Recommendation Report for Listed Building Consent for Alterations, Extension or Demolition

REF NO: Y/27/15/L

LOCATION: The Old Thatched Cottage
North End Road
Yapton

PROPOSAL: Application for listed building consent for 1 No. annexe building providing ancillary accommodation to main house.

Fig 7. Proposed west elevation

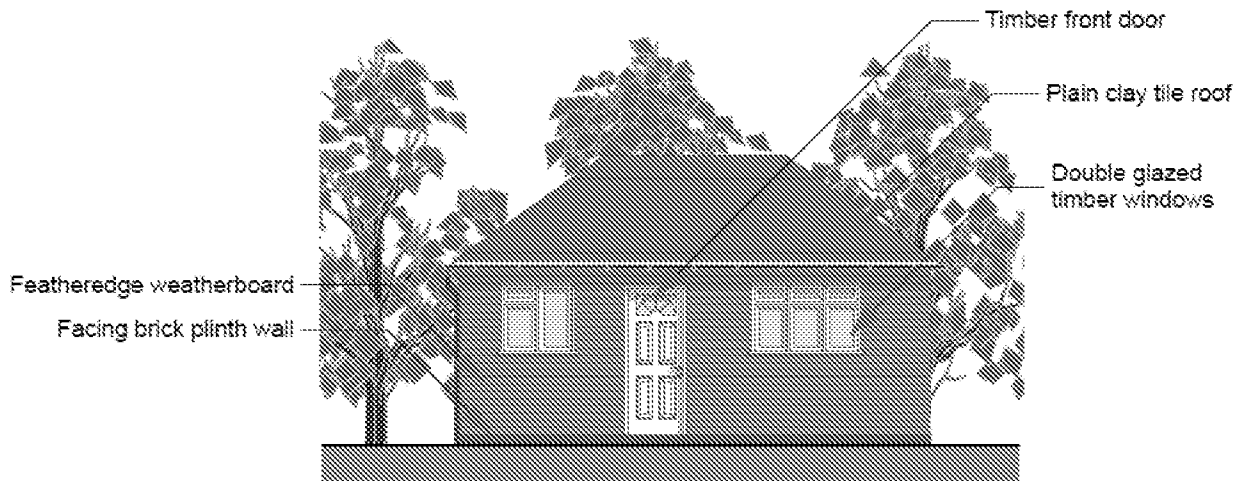
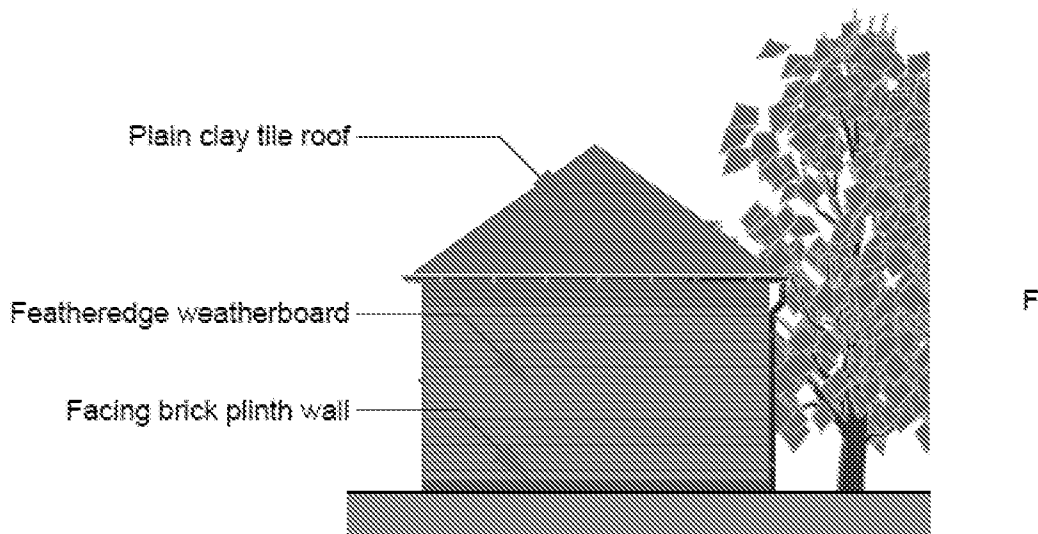
- a) Request cedar wood is used and that the door is of timber construction
- b) A condition is included to prevent the building being sold as a separate residence.

Whilst there is no objection to the scheme, the door is overly decorative for an outbuilding of this nature and should be conditioned. The windows would also benefit from being full height casements without top vents.

- 3 No development shall be carried out unless and until a schedule of materials and finishes and samples of such materials and finishes to be used for external walls, roof and door of the proposed building have been submitted to and approved by the Local Planning Authority and the materials so approved shall be used in the construction of the building.
